LOT 24-25 WAREHOUSE BUILDINGS
7358-7386 COLE VIEW, COLORADO SPRINGS, COLORADO 80915

SITE GRADING & EROSION
CONTROL PLAN

Markup Summary

SITE GRADING & EROSION
CONTROL PLAN

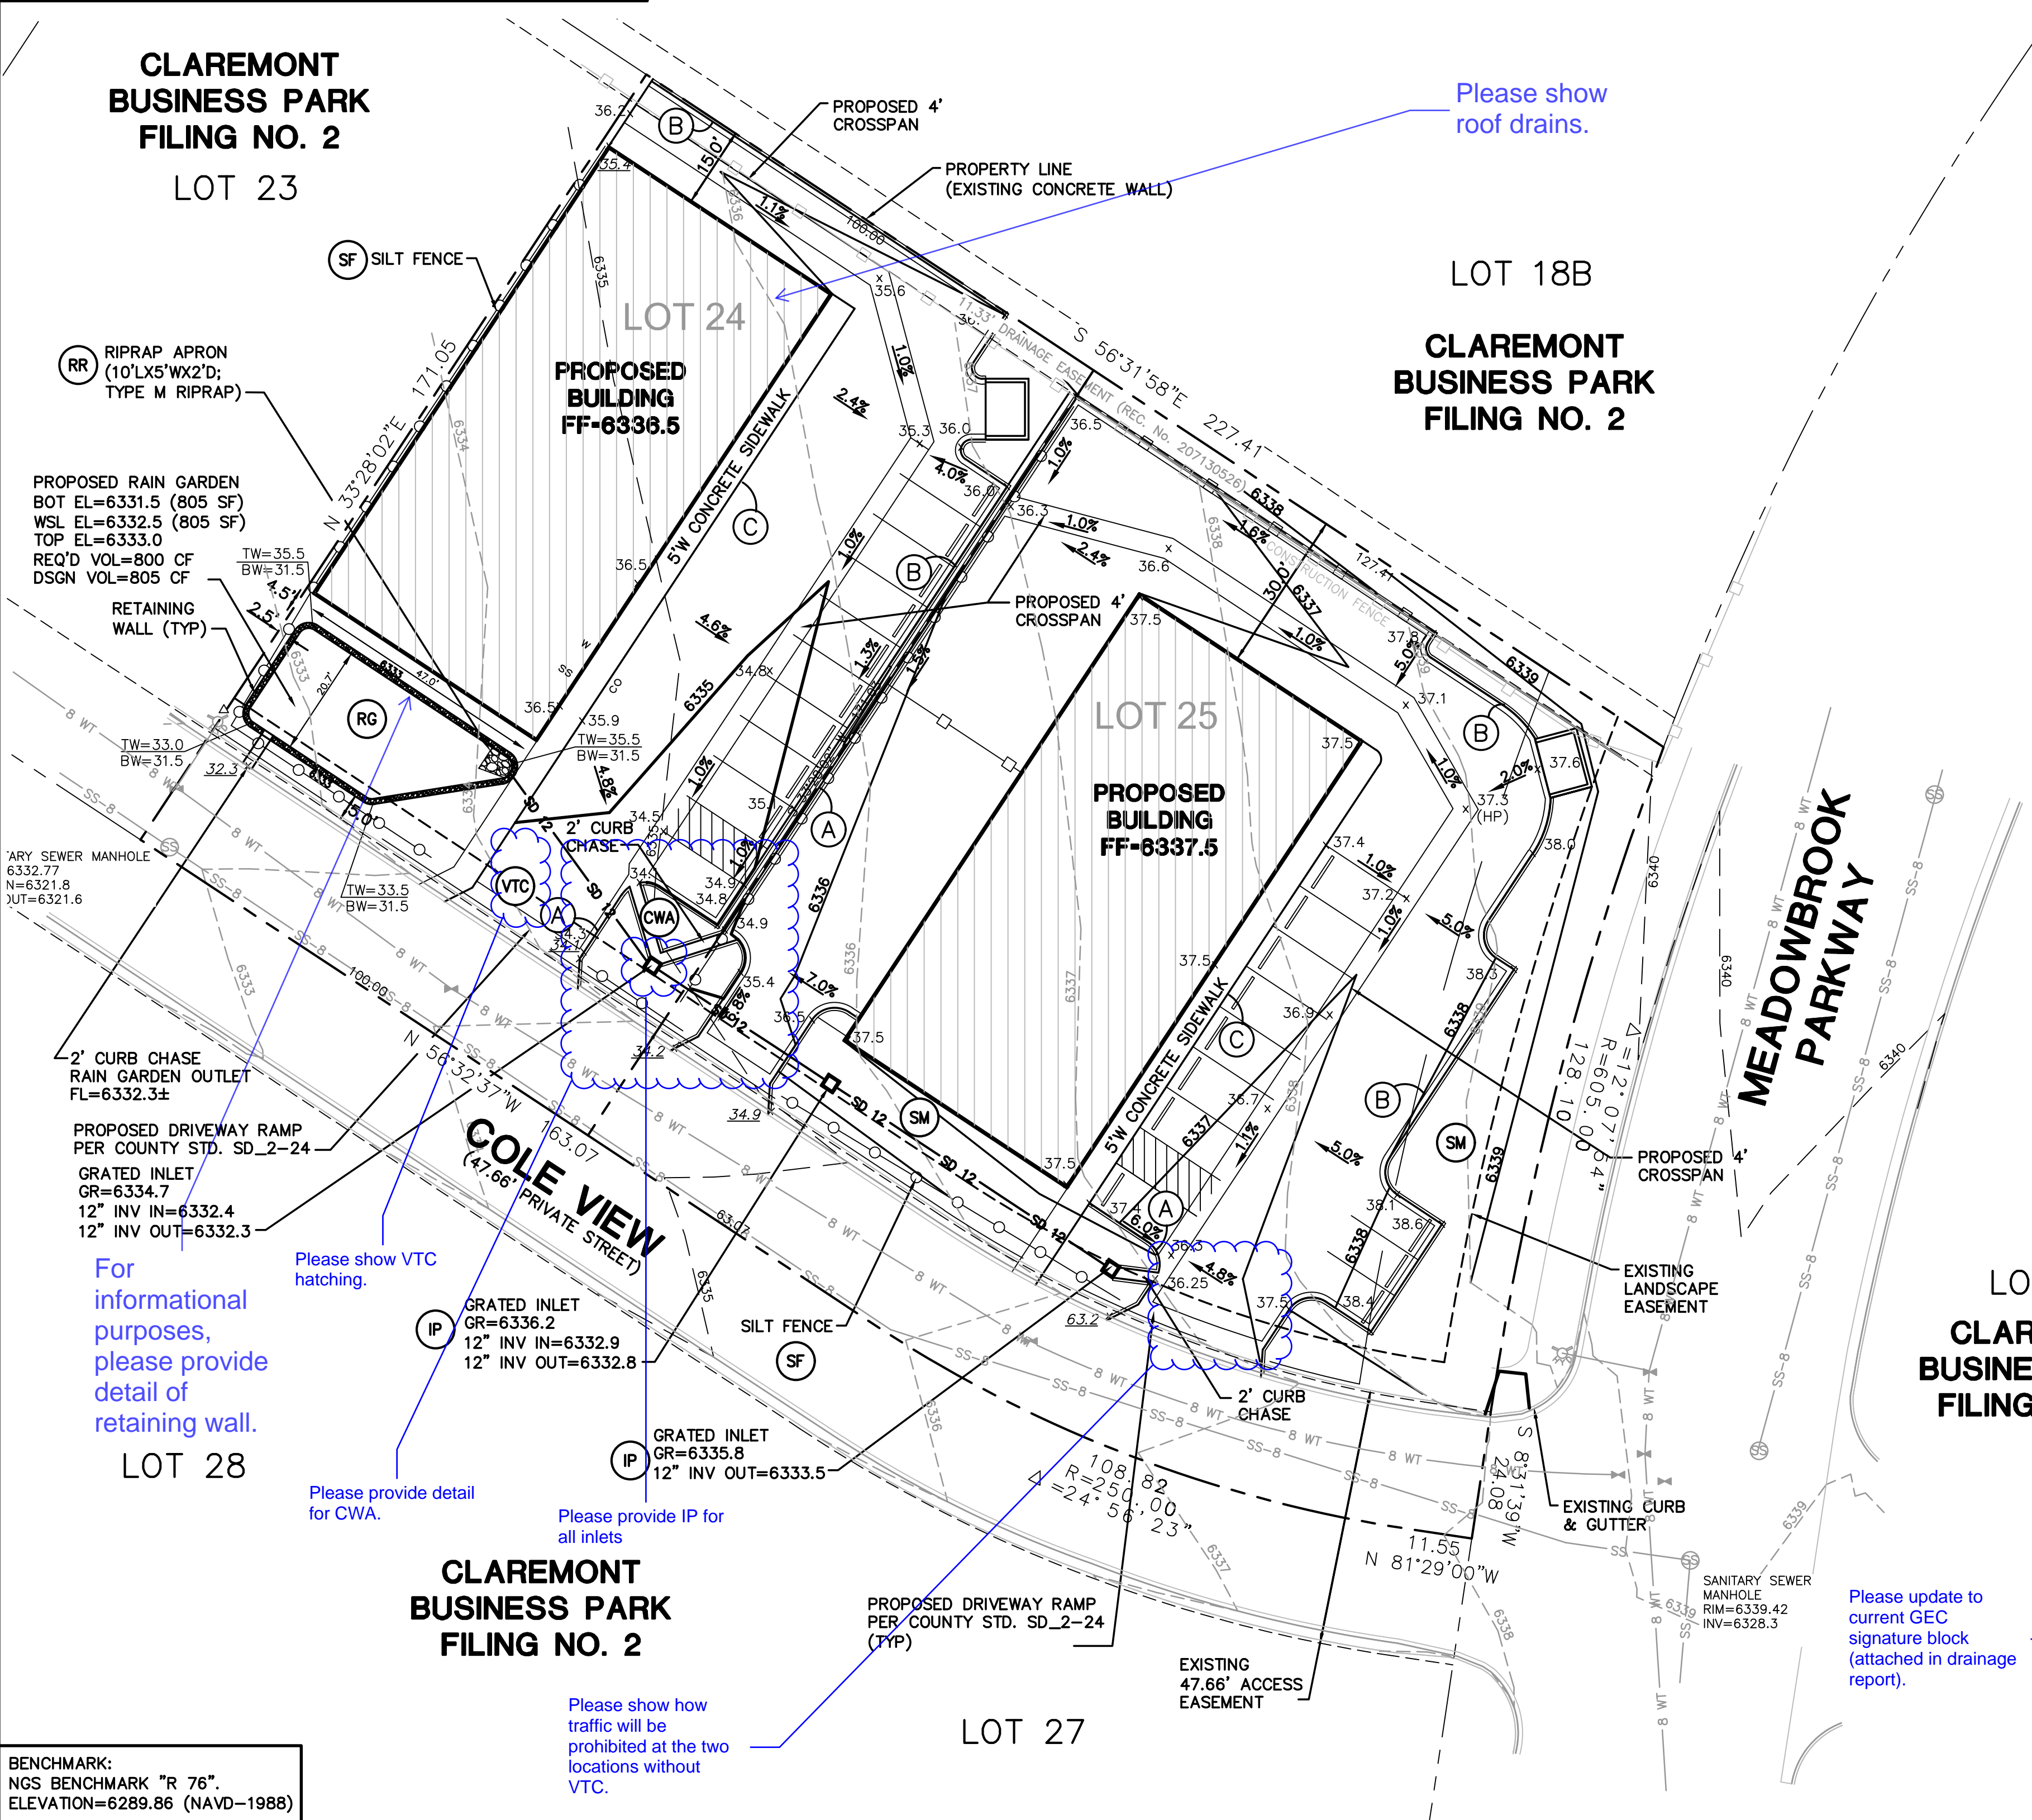
dsdlaforce (3)		
	Subject: Callout Page Label: 1 Lock: Locked Status: Checkmark: Unchecked Author: dsdlaforce Date: 10/30/2017 10:28:16 AM Color: ■	Double check grades. The grate appears to be higher than the flow line
<hr/>		
	Subject: Callout Page Label: 1 Lock: Locked Status: Checkmark: Unchecked Author: dsdlaforce Date: 10/30/2017 10:28:18 AM Color: ■	Top of curb (~34.7) is at the same elevation as the grate and does not create the 6" ponding depth per the UD-Inlet A2 calculation.
<hr/>		
	Subject: Text Box Page Label: 1 Lock: Locked Status: Checkmark: Unchecked Author: dsdlaforce Date: 10/30/2017 10:28:20 AM Color: ■	Add PCD Project No. PPR-17-036
